Land near Hodder Bridge, Chaigley

**Landscape Representations to
planning application reference
3/2021/1008**

Additional information - March 2022

01 March 2022

LANDSCAPE MASTERPLAN

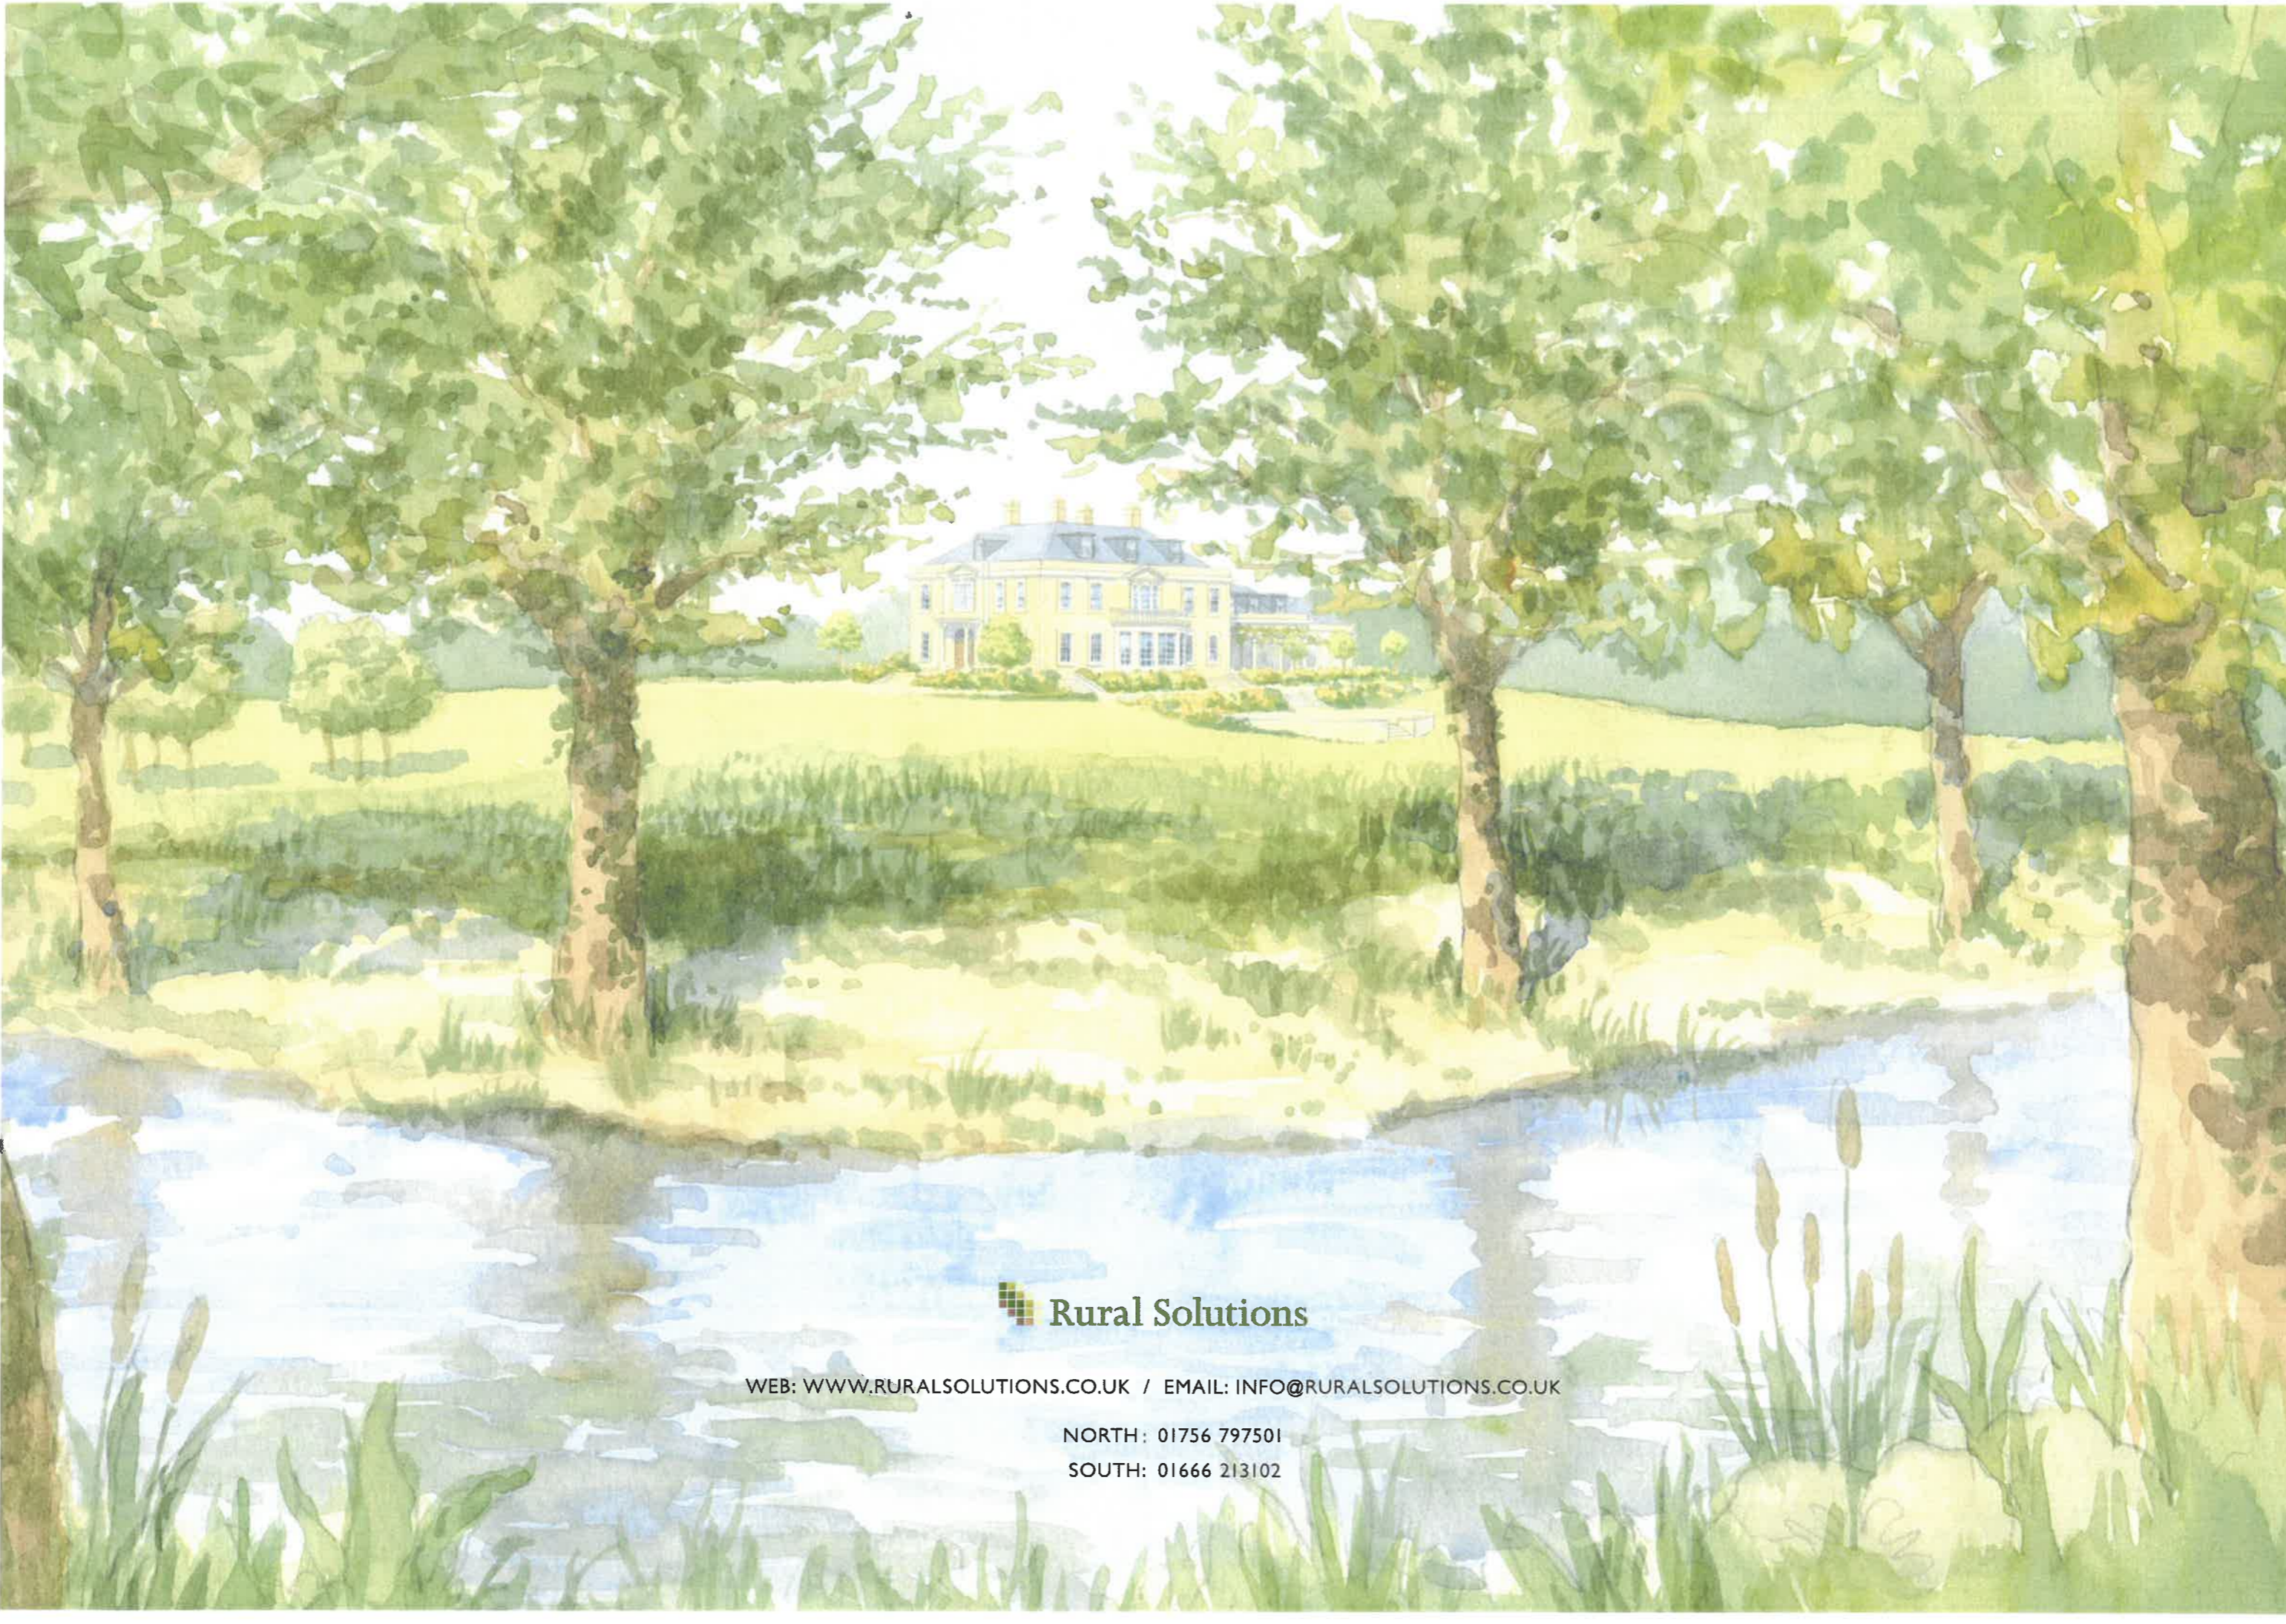
- 2.18. The latest Landscape Masterplan (Rev C) appears to have one single difference to the previously reviewed version. This is a change to the title of keyed item 13 'Access Track' where a bracket has been added to note '*maintenance, agricultural and emergency access*'.
- 2.19. This change has no impact to landscape and visual considerations as previously considered.
